Memorandum

To: Matt Grush, P.E., PTOE – Planning Department Traffic Engineer
(Albuquerque, New Mexico)

Subject: Montage Units Traffic Impact Analysis, Draft Final Response

Date: October 26, 2021

Site Plan

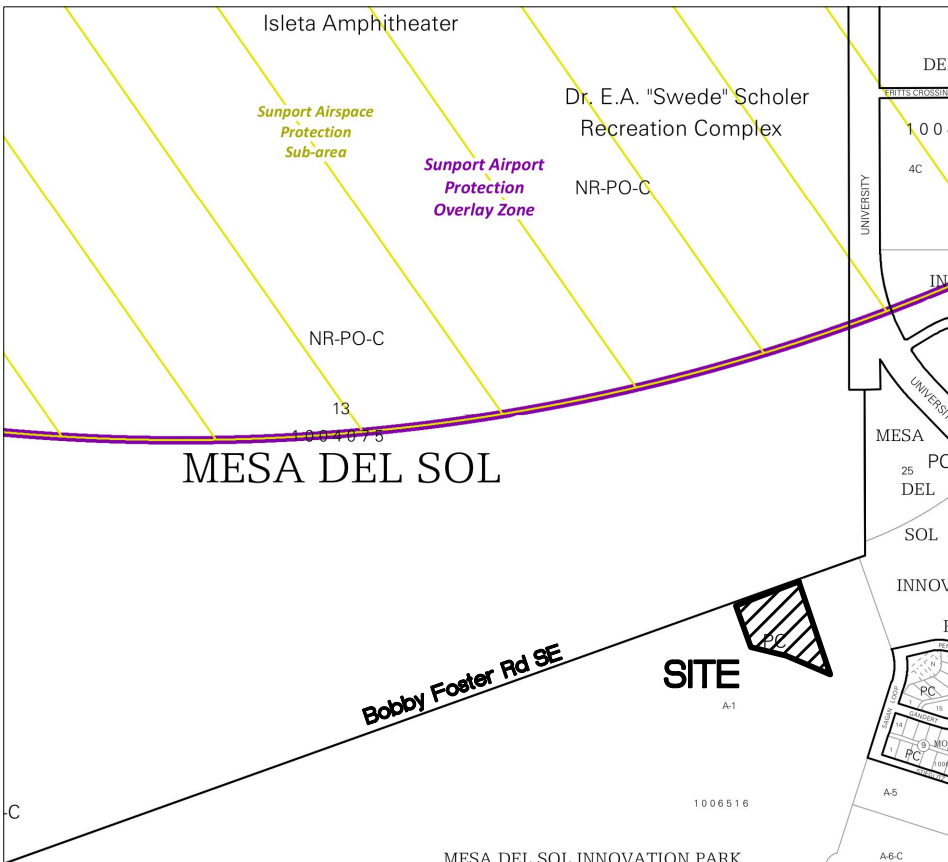
-
1. Provide access point analysis for all access for Montage from University Blvd. and also Bobby Foster Rd. Include site plan drawings with sufficient detail depicting all access points to these roads. The site plan for the Gateway Apartment dated 7/25/2021 shows a main entrance on University Blvd. between Bobby Foster Rd. and Arbus Dr. The access to the Gateway Apts. as well Arbus Dr. and any other access that are not in the draft final report are to be included in the final report.

2. Provide a drawing showing the proposed geometric relationship with the connection between Montage Units and the Regional Sport Complex specifically Diebenkorn Dr, Newhall Dr, Sagan Loop, Multi-Family Housing driveway.

Reevaluated trip distributions for the Multi-Family Housing according to the site plan 7/25/2021. Added intersections 10 (Multi-Family Homes Driveway and University Blvd) and 11 (Arbus Dr and University Blvd) to the report and figures. Used Synchro to run traffic models for Intersections 10 and 11. Reran Synchro models for all Intersections.

The Regional Sports Complex TIA should show connections to the roadway network. Included in Appendix E, Figure (AS100) was used to distribute trips from sports complex to the connecting streets with the Montage Units.
